DESCRIPTION OF REQUEST: Final Sign-off for EPC Approved Site Development Plan for Subdivision

**RE: JEFFERSON & OSUNA
SITE DEVELOPMENT PLAN FOR SUBDIVISION
CONDITIONS OF APPROVAL-15 EPC-40021**

Project# 1005517
15EPC-40021 Site Plan for Subdivision

Drawing file: 1005517_ApplicationDoc / 1_sheet 1a site plan.pdf

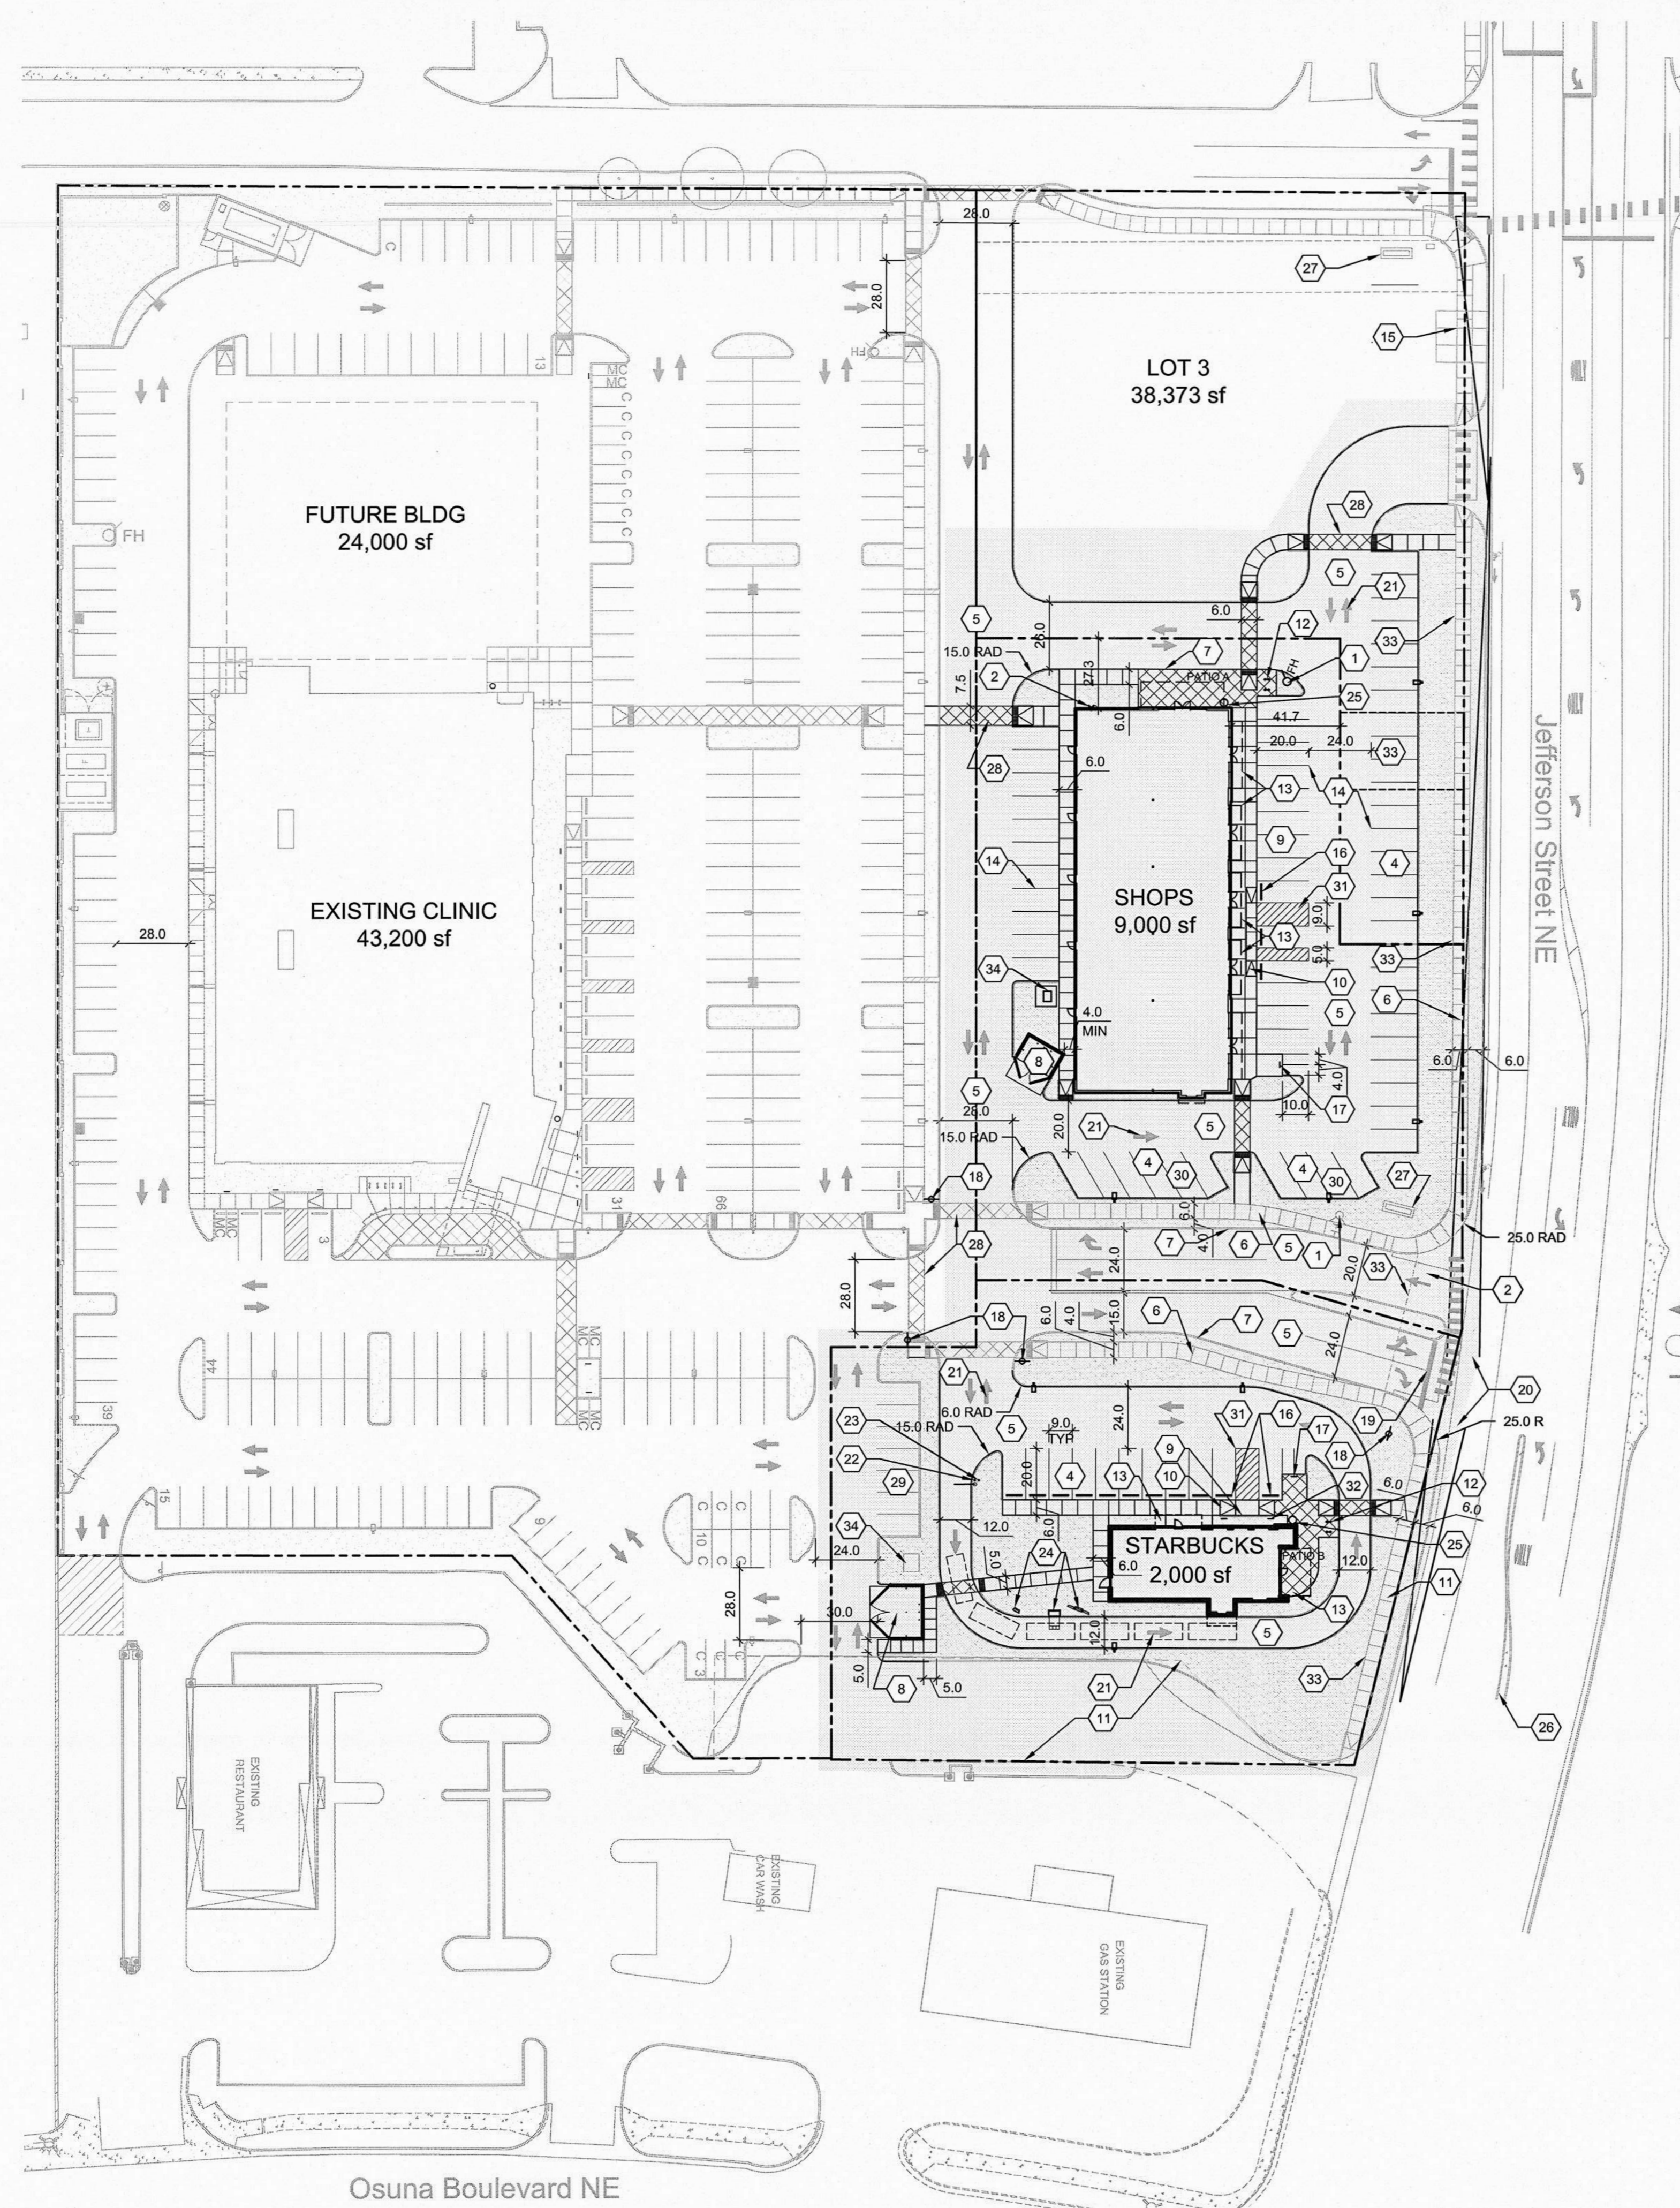
4. Site Development Plan for Subdivision:
The monument sign proposed along the private drive, on the subject site's northern side, shall be removed because it is not allowed pursuant to Zoning Code 14-16-3-2, Shopping Center Regulations.

The sign along the private drive was removed from the plan as shown on the Site Development Plan.

- C. Show existing sidewalk facilities on Osuna and on Jefferson. Label existing driveway width for the westernmost driveway onto Osuna Road. Also, show all three existing driveways and respective driveway widths off of Osuna Road that are being utilized by the proposed development as indicated in the Traffic Impact Study dated May 28, 2015.

Existing sidewalk facilities on Osuna & Jefferson and existing drives with respective widths on Osuna were added to the Site Plan for Subdivision (see attached redlines).
